## Kirkburton Parish Council comments on Kirklees Plan List 6 – 12 March 2023

The following applications were considered by Kirkburton Parish Council at the meeting on 6 April 2023. The Parish Council's comments are detailed below:

Title: External Works

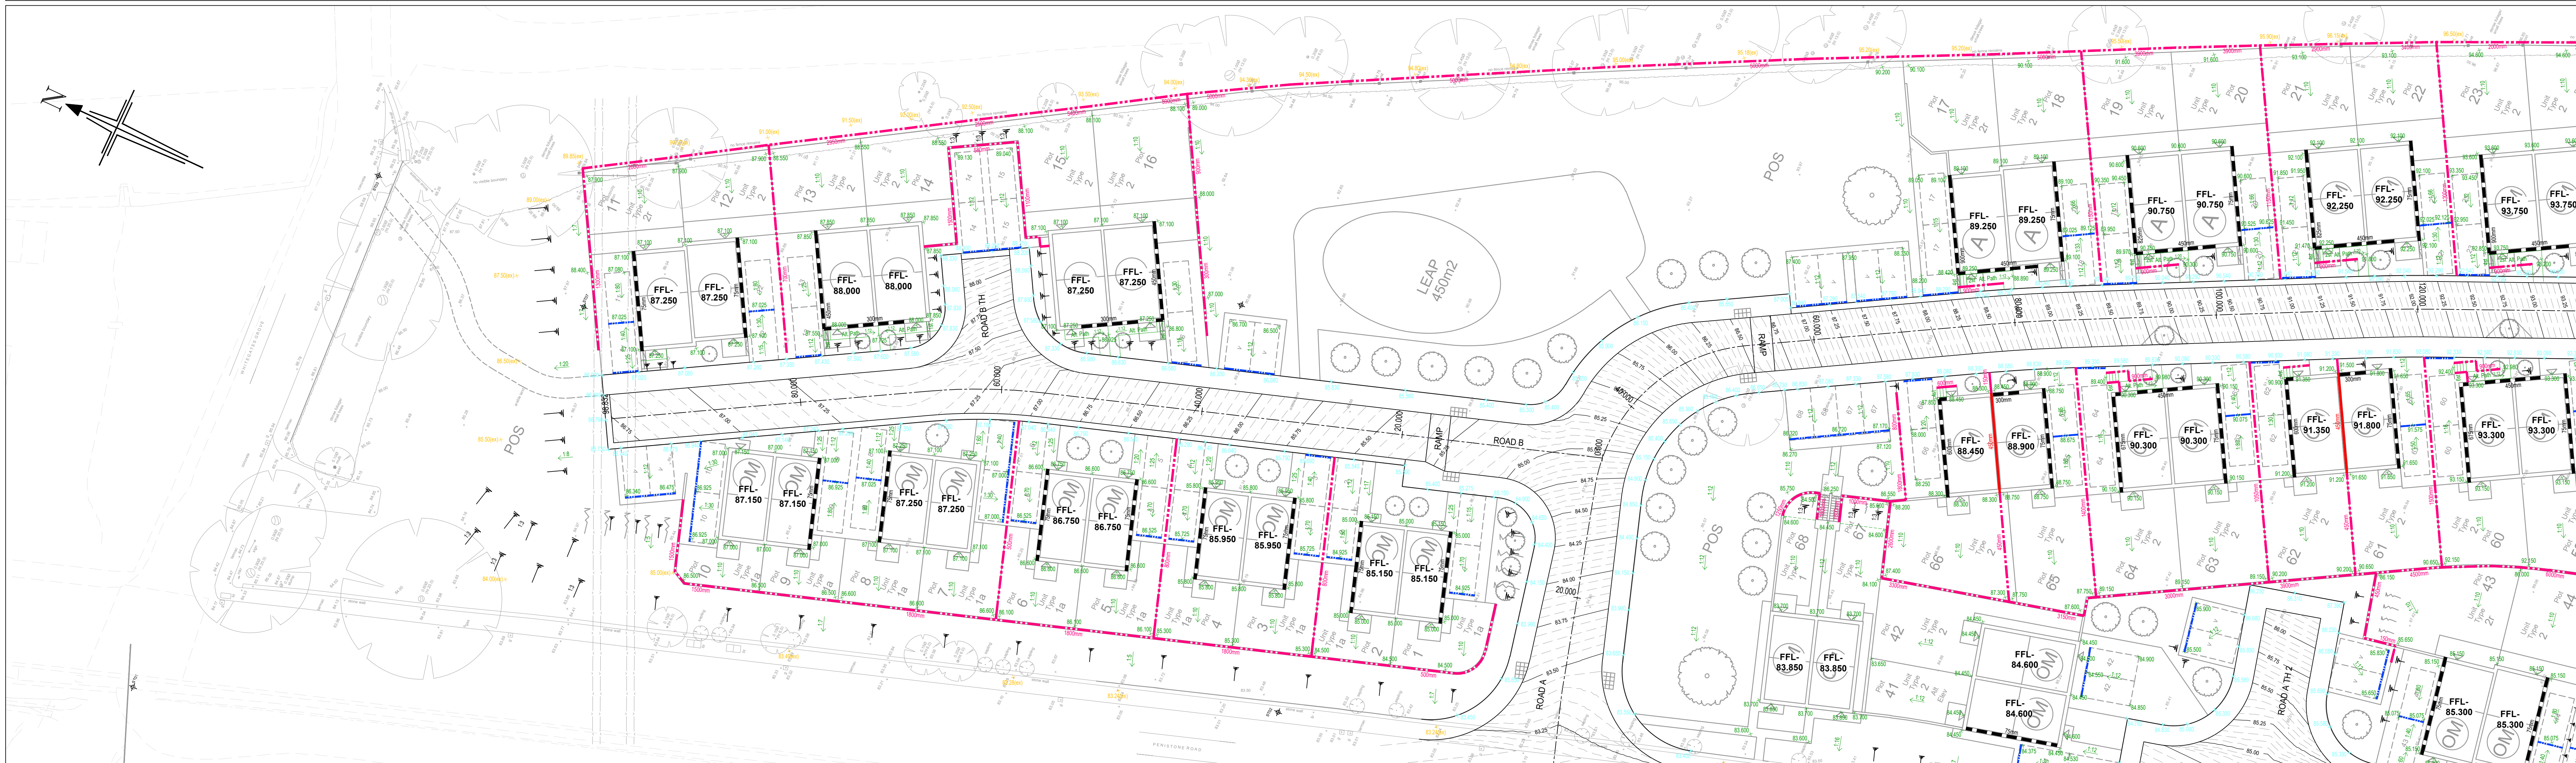
| Application and Details                                                                                                                                                                                                                                                                                                                                                                                                                                                                                                                                                                                                                                                                                                                                                         | Kirklees Officer  | Kirkburton PC Recommendation                                                                                                                                                                                                    |
|---------------------------------------------------------------------------------------------------------------------------------------------------------------------------------------------------------------------------------------------------------------------------------------------------------------------------------------------------------------------------------------------------------------------------------------------------------------------------------------------------------------------------------------------------------------------------------------------------------------------------------------------------------------------------------------------------------------------------------------------------------------------------------|-------------------|---------------------------------------------------------------------------------------------------------------------------------------------------------------------------------------------------------------------------------|
| <p>2023/44/90773/W<br/>Land at, Penistone Road, Fenay Bridge (Lepton ward)</p> <p>Applicant: Newett Homes</p> <p>Description / Development:<br/>Discharge Conditions 4 (highway works), 5 (right turn lane), 6 (internal adoptable estate roads), 8 (retaining walls/structures), 9 (surface water), 10 (highway survey), 11 (surface water and land drainage), 12 (storm events), 13 (surface water drainage), 15 (archaeological evaluation), 16 (soft landscape), 18 (Biodiversity Net Gain Assessment), 19 (EDS) on previous permission 2020/90725 for erection of 68 dwellings with associated access, parking and open space (revised plans)</p> <p>Deadline date for comment:<br/>See <a href="http://www.kirklees.gov.uk/planning">www.kirklees.gov.uk/planning</a></p> | <p>Nick Hirst</p> | <p>The Parish Council objects on Highways' grounds: the carriageway is too narrow on Penistone Road (section past Rowley Lane). Also, there is no provision for pedestrians to cross Penistone Road to get to the bus stop.</p> |
